From: Michael Eastham <Michael.Eastham@arun.gov.uk>
Sent: 04 January 2022 08:20
To: Planning.Responses <Planning.Responses@arun.gov.uk>
Subject: FW: Land At Salt Box West Of Shripney Road Bognor Regis PO22 9NW - BE/168/21/DOC

Planning Application Reference: BE/168/21/DOC

Proposal: Approval of details reserved by condition imposed under BE/135/18/PL relating to Outline conditions 20-noise report, 21-renewable or low carbon energy sources & 22-external lighting & Full Planning conditions 12-surface water drainage systems, 13-discharge of flows to watercourses, 14-maintenance & management of surface water drainage system & 16-foul drainage system.

Address: Land At Salt Box West Of Shripney Road Bognor Regis PO22 9NW

Plan View
Scale - 1 : 1000

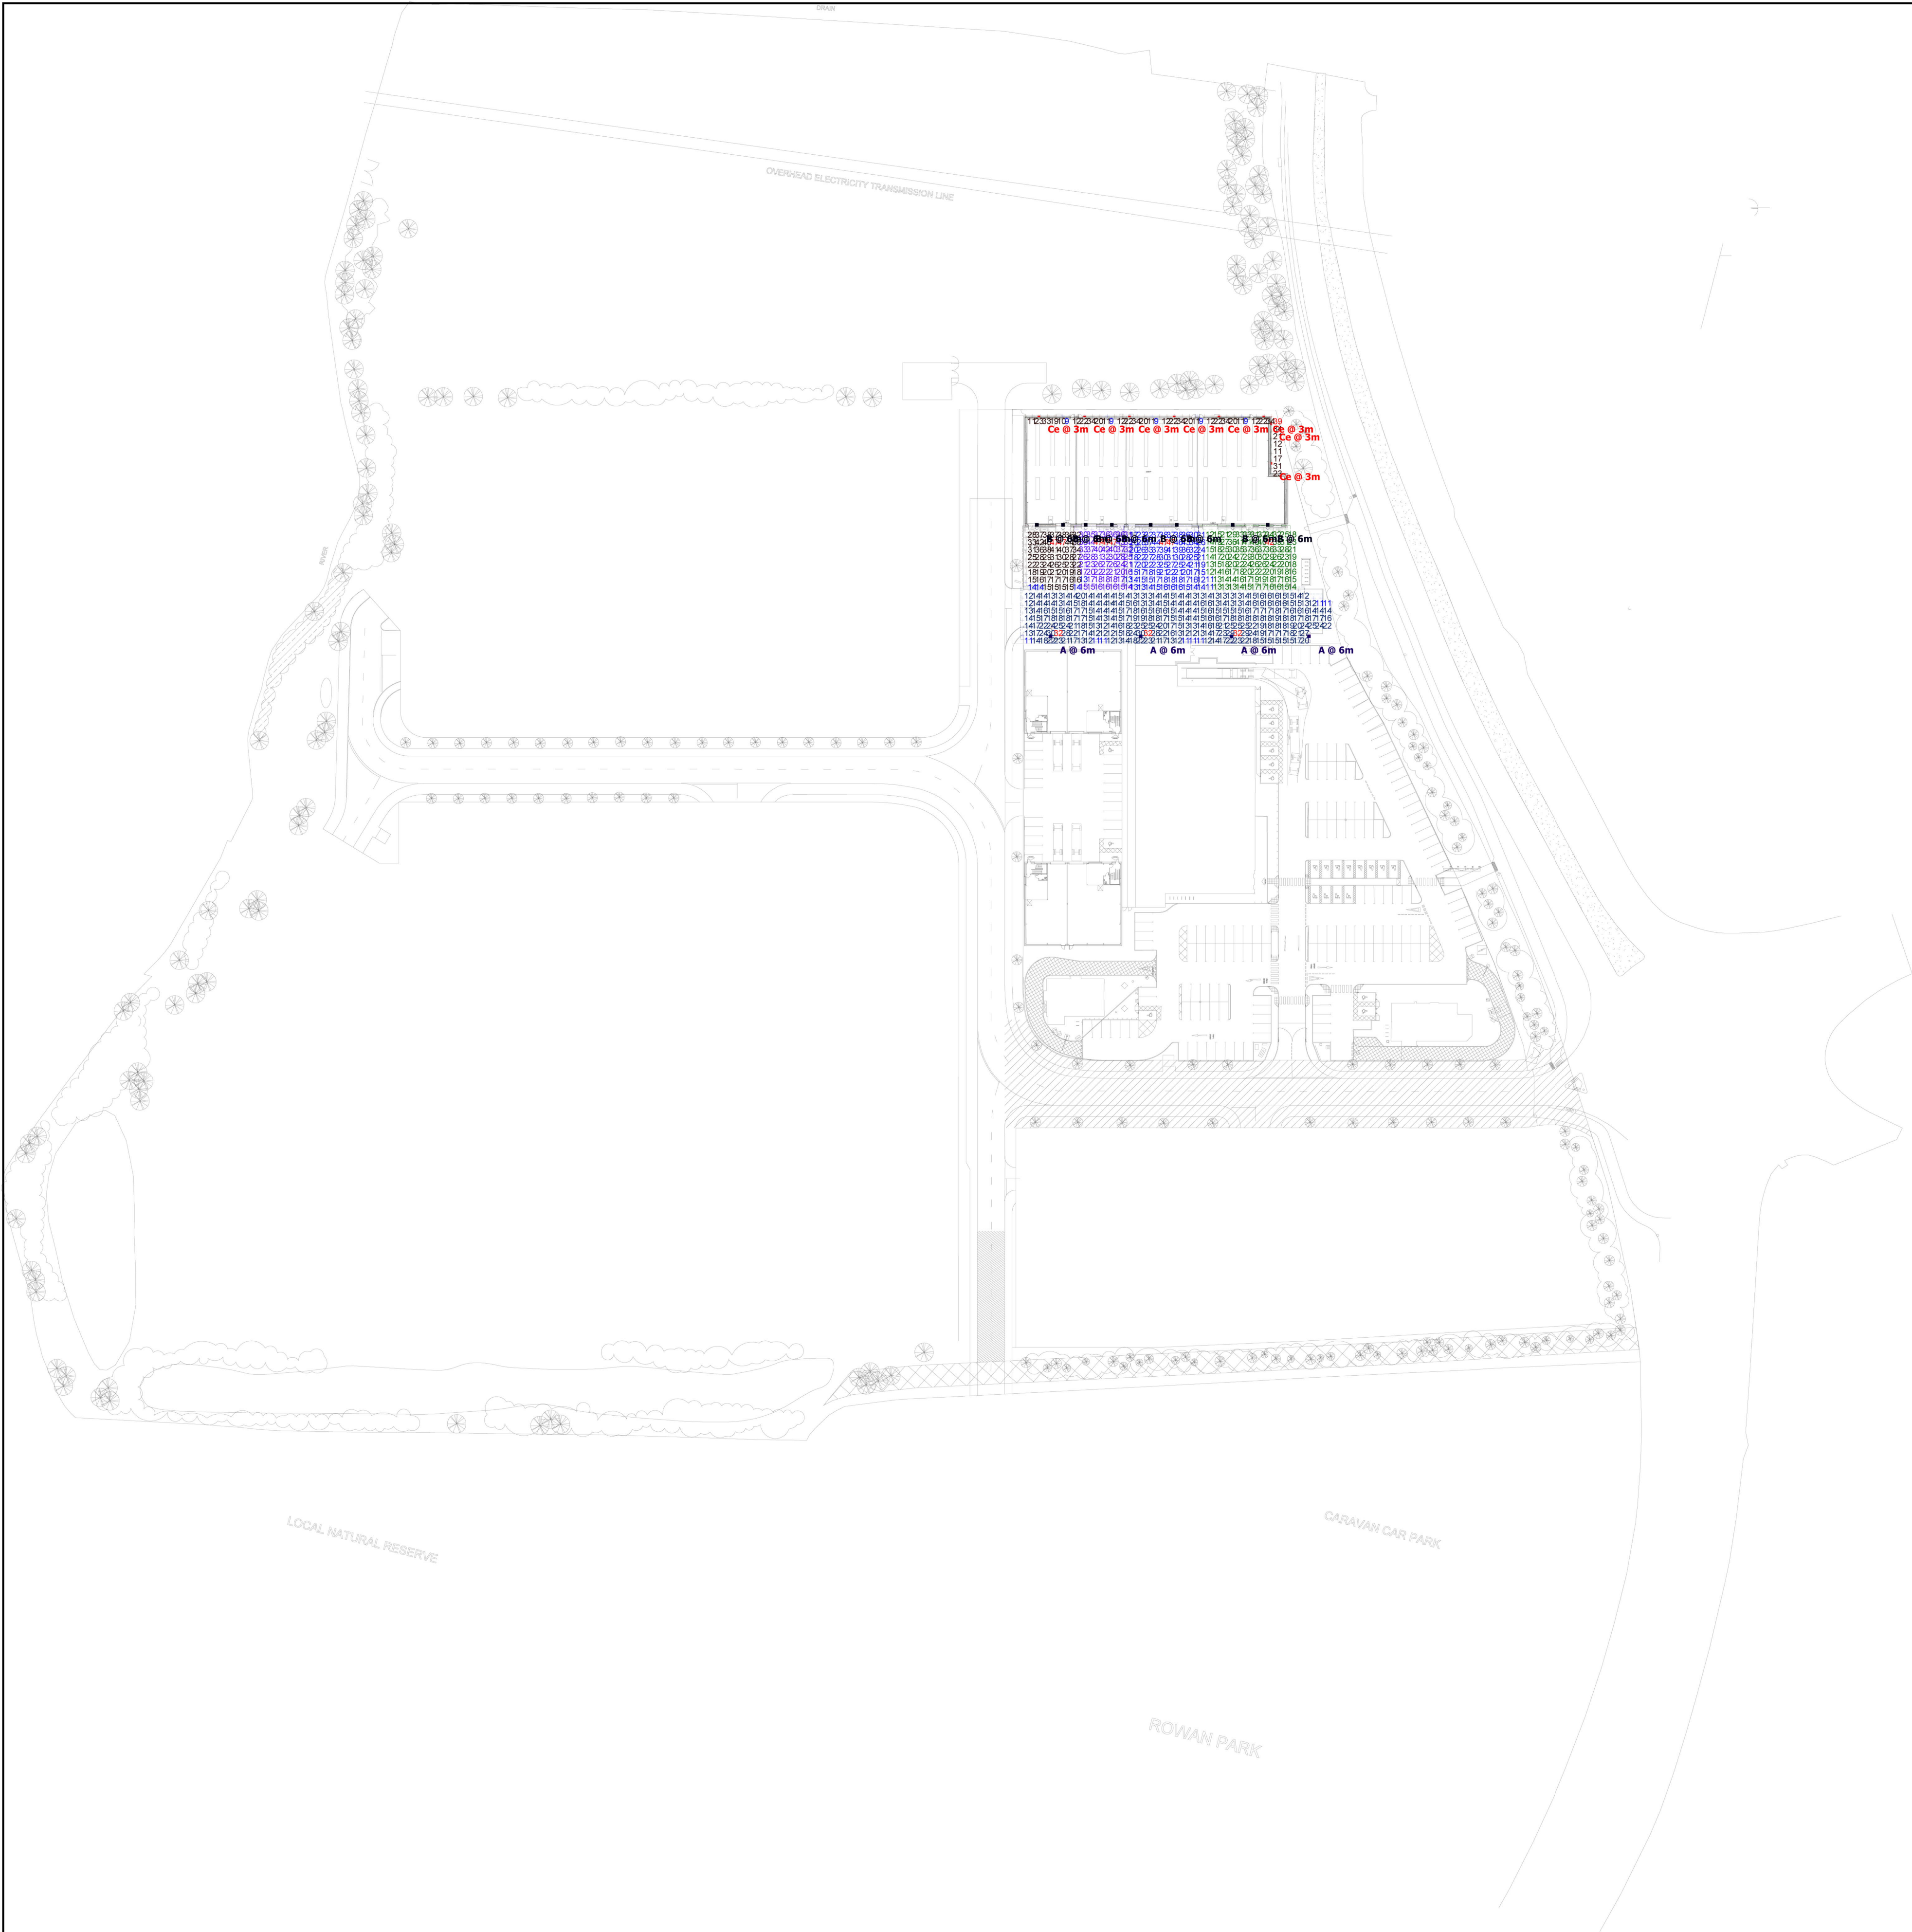
I note the proposed external lighting is Holophane D-series wall and single column, and Denver elite wall mounted. Having reviewed the catalogues I can confirm these lights incorporate design to minimise glare, spill and sky glow.

The following information is required to discharge the condition.

1. Details of zone E2 lighting luminaires (lux levels)
2. Timings of lighting

Having reviewed the document entitled 'Saltbox – Development | Landlink Developments | External Lighting Statement Unit 3 | Revision 0' (dated 3.12.2021) [produced by Scotch Partners] I find the document to be reliable and the content sufficient to discharge condition 22.
